Recommendation Report for Planning Permission for Works or Extension to a Dwelling

REF NO: BE/122/24/HH

LOCATION: 15 Wren Crescent
Bersted
PO22 9BZ

PROPOSAL: Loft conversion including rear dormer and front rooflights and alterations to fenestration.

PROPOSED
First Floor Plan

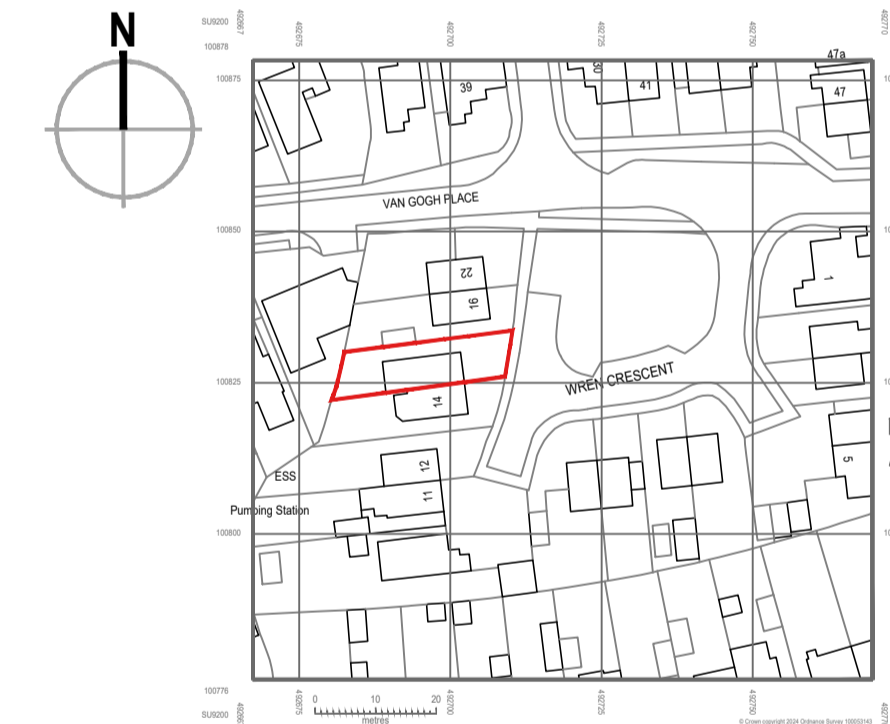
The proposed loft conversion would create habitable space at first floor level. However, a similar development of a dormer of a similar size and scale and front rooflights could be achieved under permitted development. Furthermore, the proposed dormer would be set down from the original roof ridge height and would not reduce the separation distance between the host dwelling and the neighbours to the west. The rear dormer would not be visually subservient, integrated, nor a minor addition to the existing roof slope, however given the siting of this element, and that a similar dormer could be achieved under permitted development, the rear dormer is acceptable in this regard.

PROPOSED
North Elevation

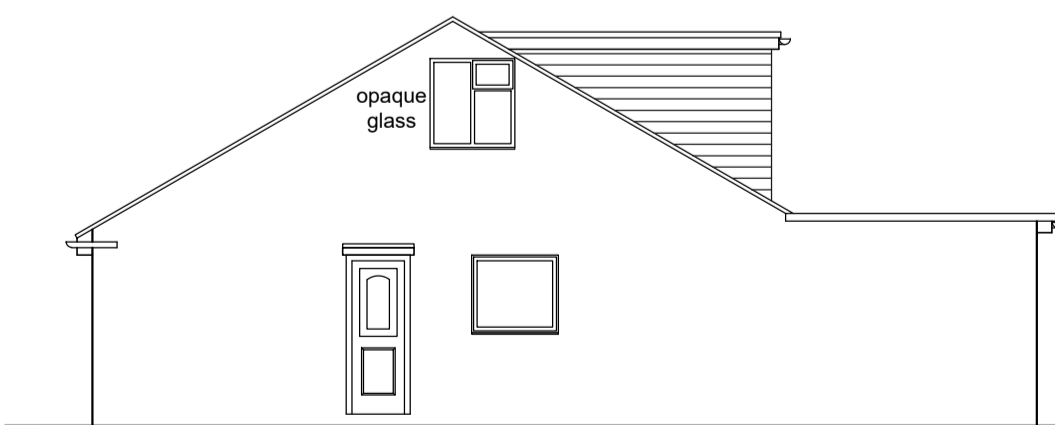
- 3 The first floor window within the northern flank elevation of the building shall at all times be glazed with obscured glass to a level equivalent to Pilkington Level 3 or nearest equivalent standard and be non-openable below 1.7m above finished floor level. This arrangement shall be permanently retained thereafter.

PROPOSED
West Elevation

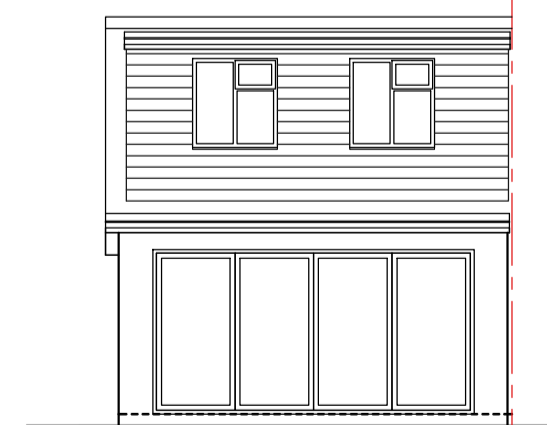
The rear dormer would measure approx. 3.9m in depth, 5.6m in width and 2.2m in height. Two windows are proposed (white uPVC) to the west (rear) elevation. The walls of the dormer are to be clad with tile hanging to match existing and the flat roof is to be of felt or EPDM. The windows are to be of white uPVC.

The windows proposed in the west (rear) facing roof plane of the extension would look onto the rear garden amenity and would be set back from the rear boundary fence by approx. 7m. Whilst views of neighbouring gardens and property would be available, these views would not be dissimilar to those which could be achieved via constructing a rear dormer under permitted development. Therefore, the proposed dormer is acceptable in this regard. A window is proposed at first floor level within the northern flank gable end. The submitted plans indicate that this window would serve a bathroom and would be obscurely glazed. Given the relationship between the host dwelling and the neighbour to the north, a condition is attached to require this window to be obscurely glazed and non-openable below 1.7m above
